# City of Albuquerque

RE: CONC. GRADING & DRAINAGE PLAN FOR TRACT A-1 & A-2 (A-13/D8)  
RECEIVED NOVEMBER 30, 1994 FOR FINAL PLAT APPROVAL  
ENGINEER'S STAMP DATED 11-29-94

CONCEPTUAL DRAINAGE PLAN  
PROPOSED PLATTING:  
TRACTS A-1A, A-2B AND A-2A  
SEVEN BAR RANCH  
NOVEMBER, 1994

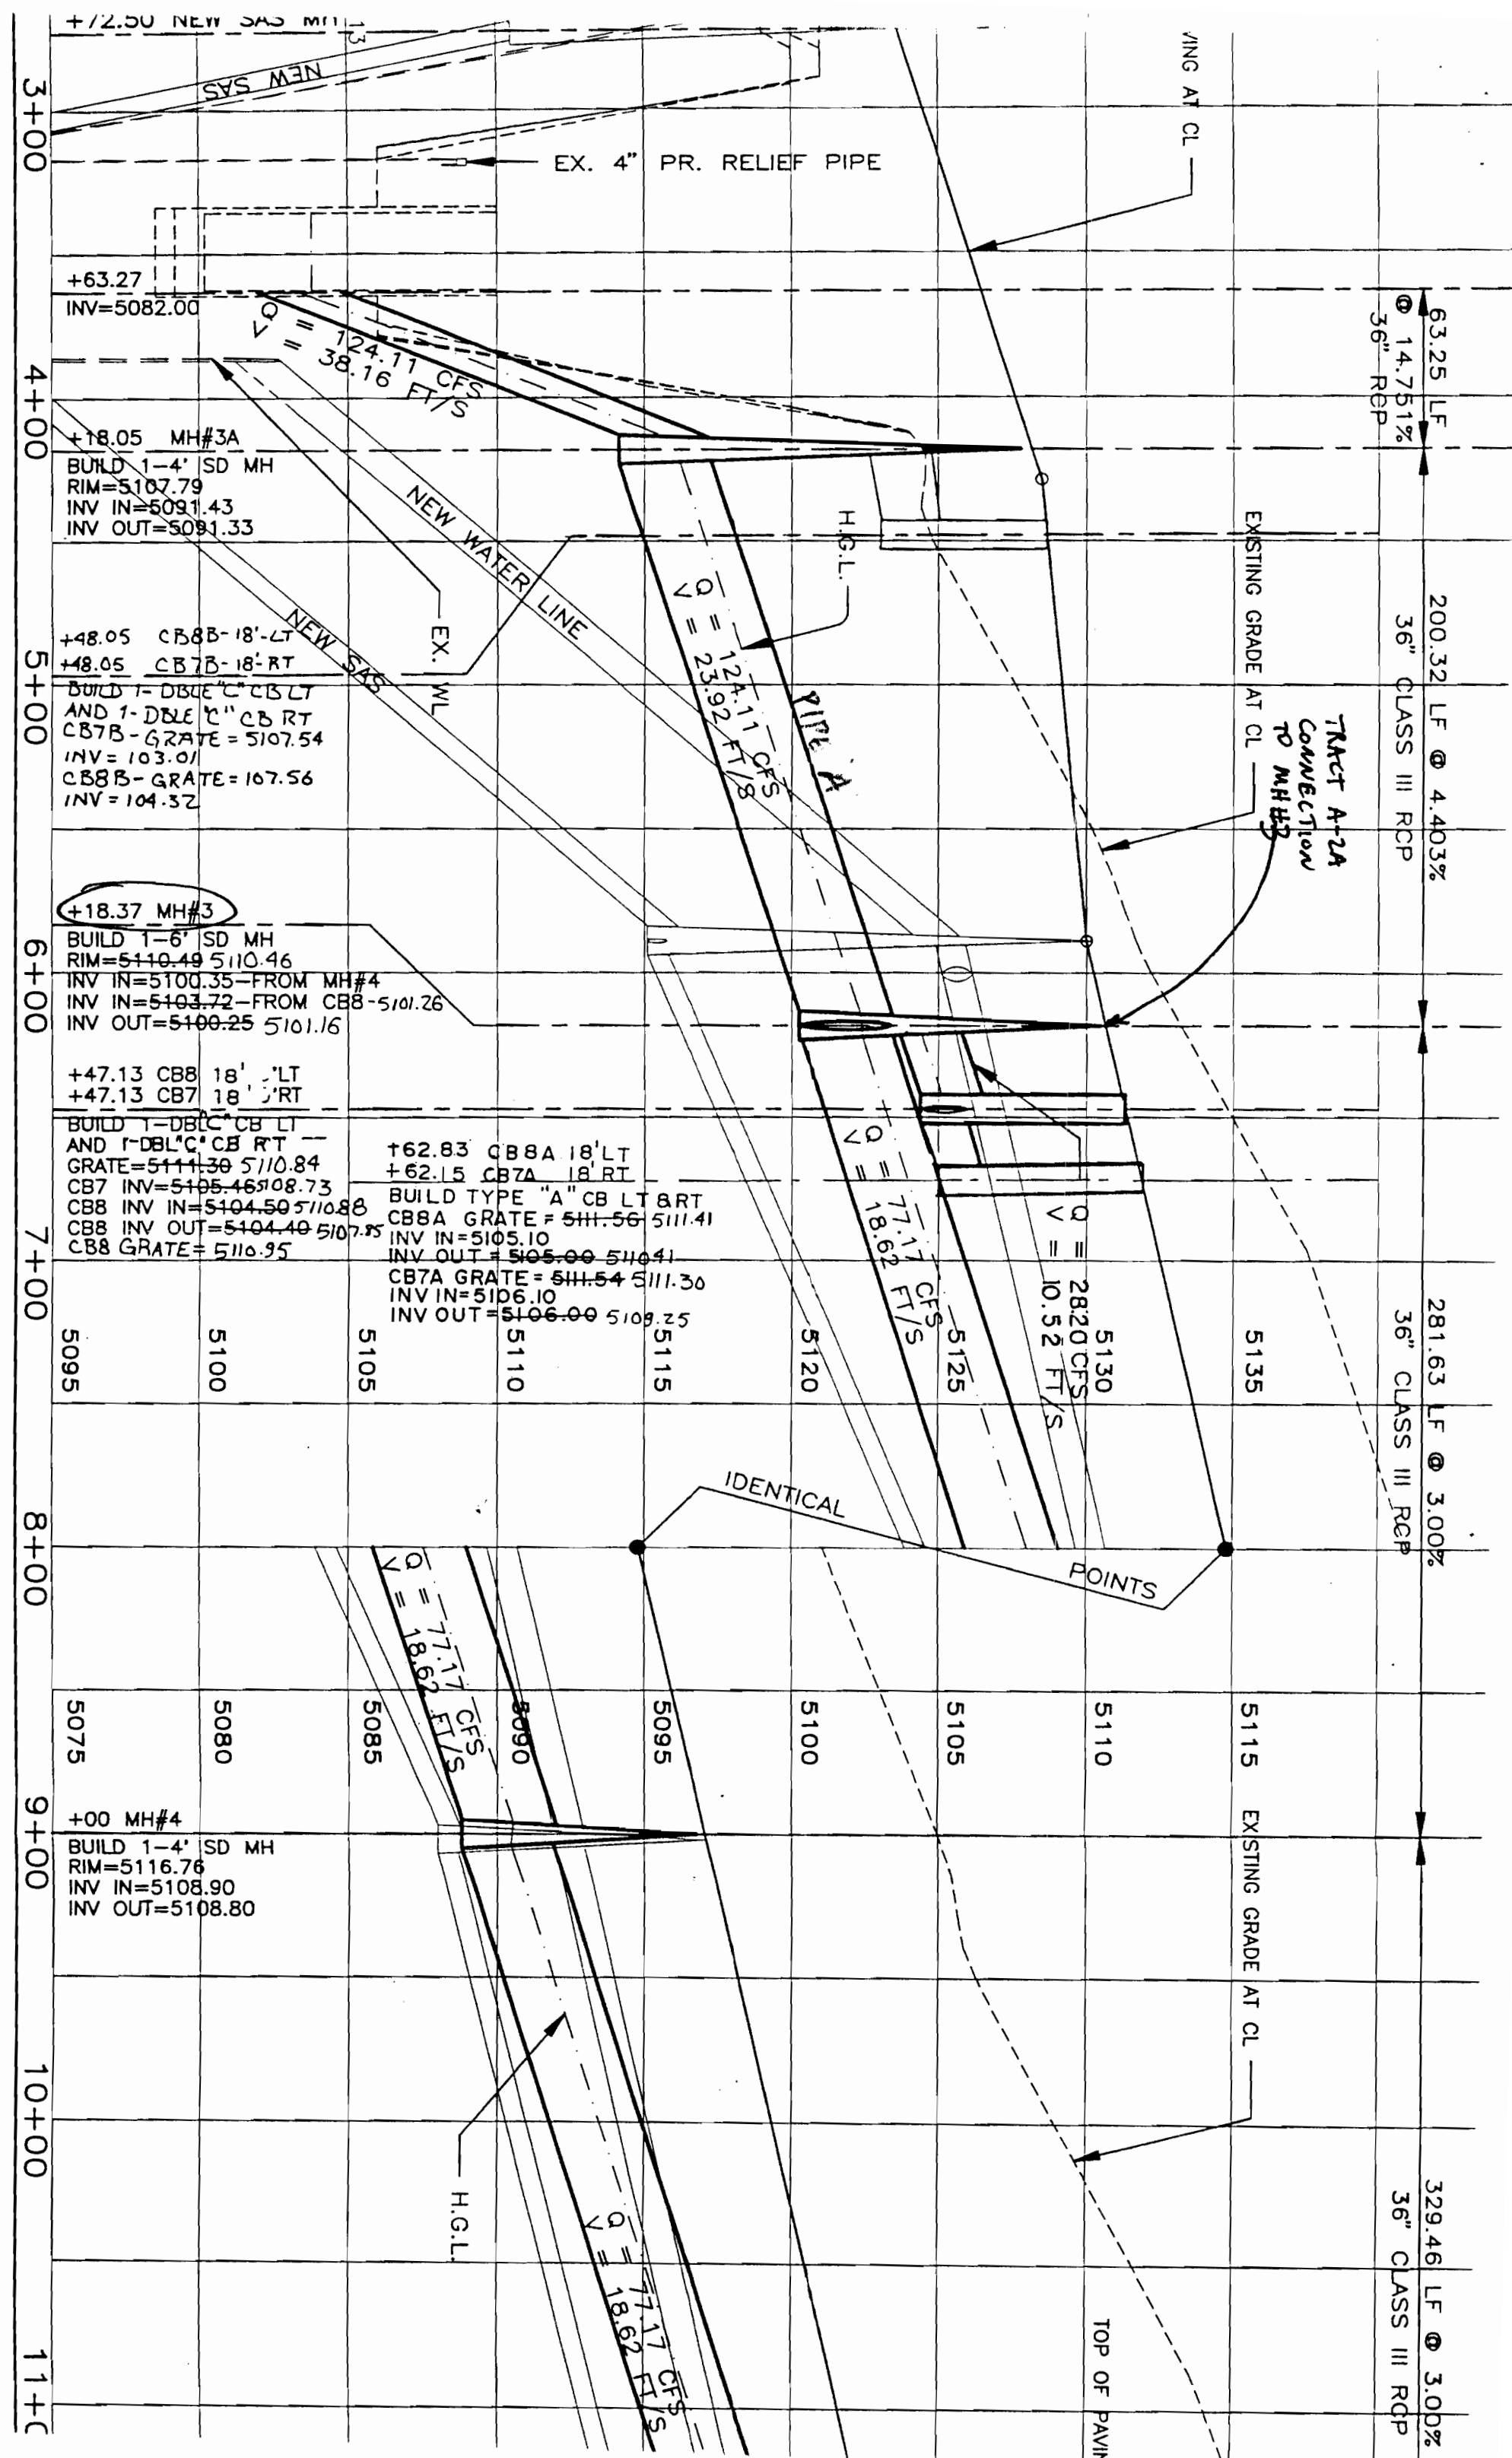
Provide calculations for the interim conditions used to design the swale and desiltation pond. Since the velocity is greater than 3 fps the swale must be lined. The outlet to the desiltation pond must be designed to handle both the 10 year & 100 year storm. Provide a sketch of the outlet structure.
